re: **Geotechnical Design Summary Details**
Metric Homes – Block 123
950 Terry Fox Drive – Ottawa

date: March 5, 2026

file: PG2855-MEMO.76 Revision 1

TCB  
 RGJ  
 TCB  
 RGJ  
 RGJ

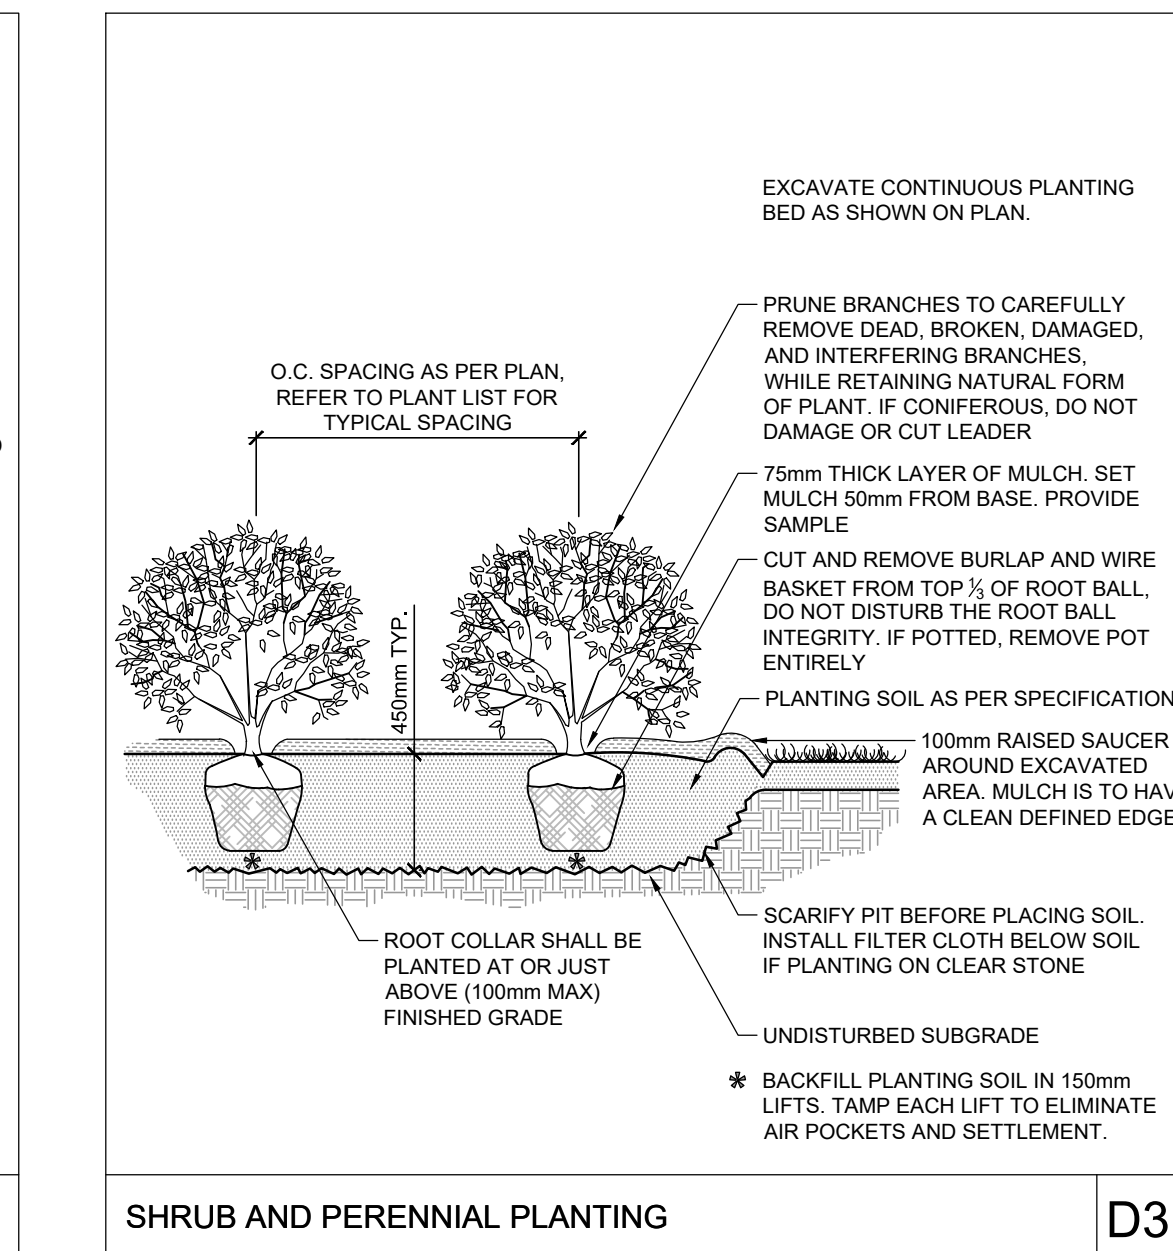
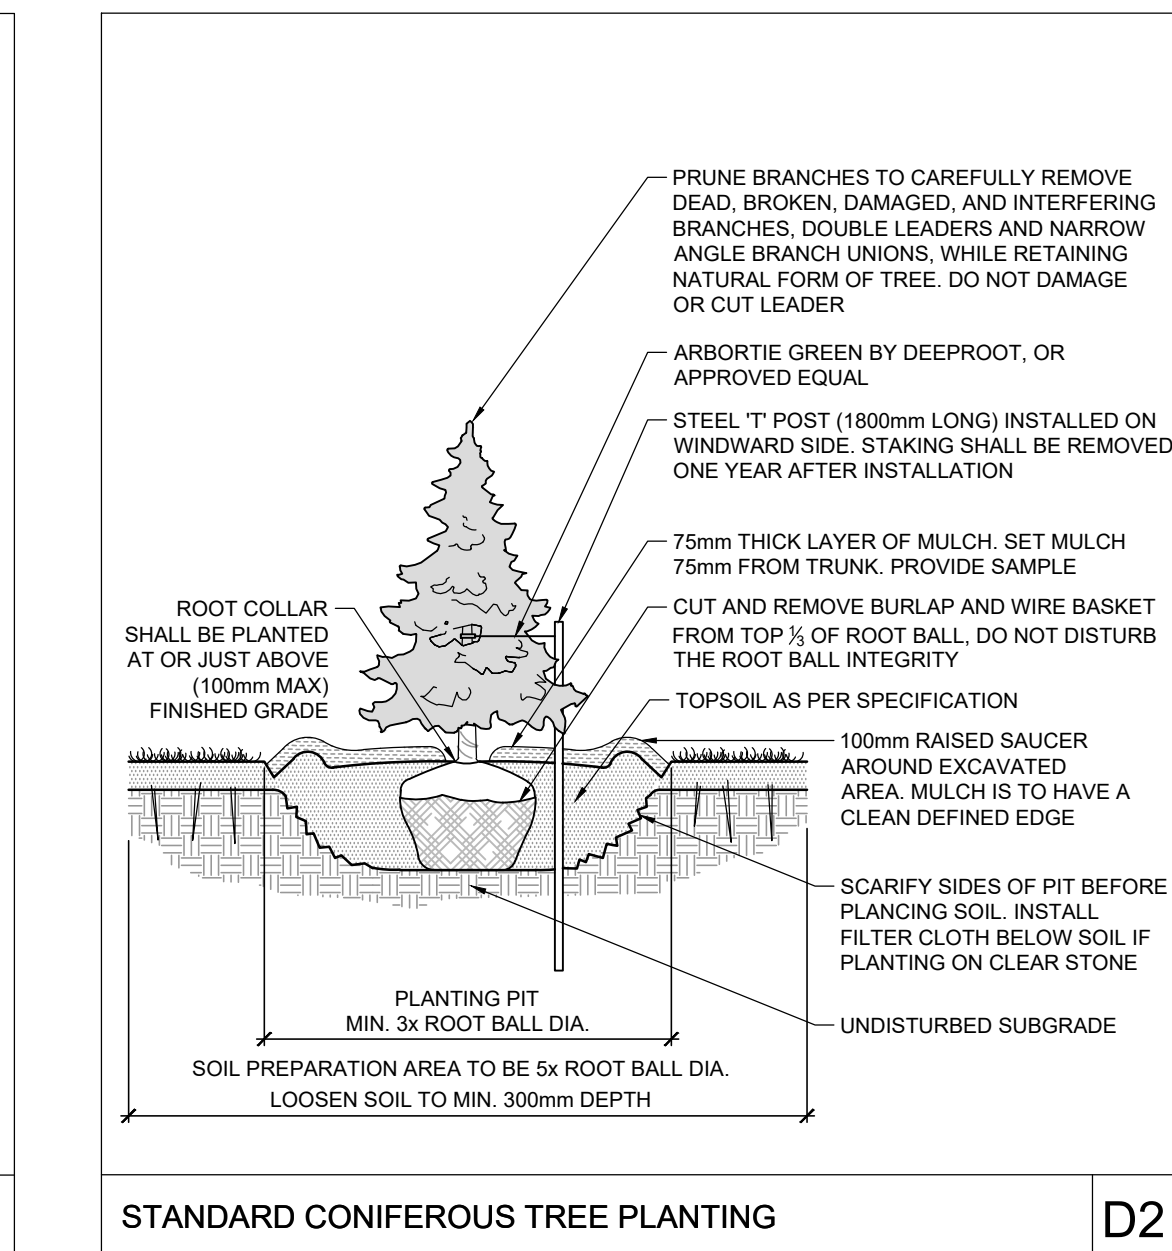
- ❑ Landscape Plan and Tree Conservation Plan – Block 123, 4829 Abbott Street East, Kanata — Drawing No. 110037-B123-L1 – Project No. 110037 – Revision 5 dated February 12, 2026.

Based on the above-noted drawing, a minimum setback of 4.5 m from the nearest building foundation is provided for all proposed small and medium trees at the subject site. Furthermore, a setback equal to, or greater than, the mature tree height is provided for all proposed large trees at the subject site.
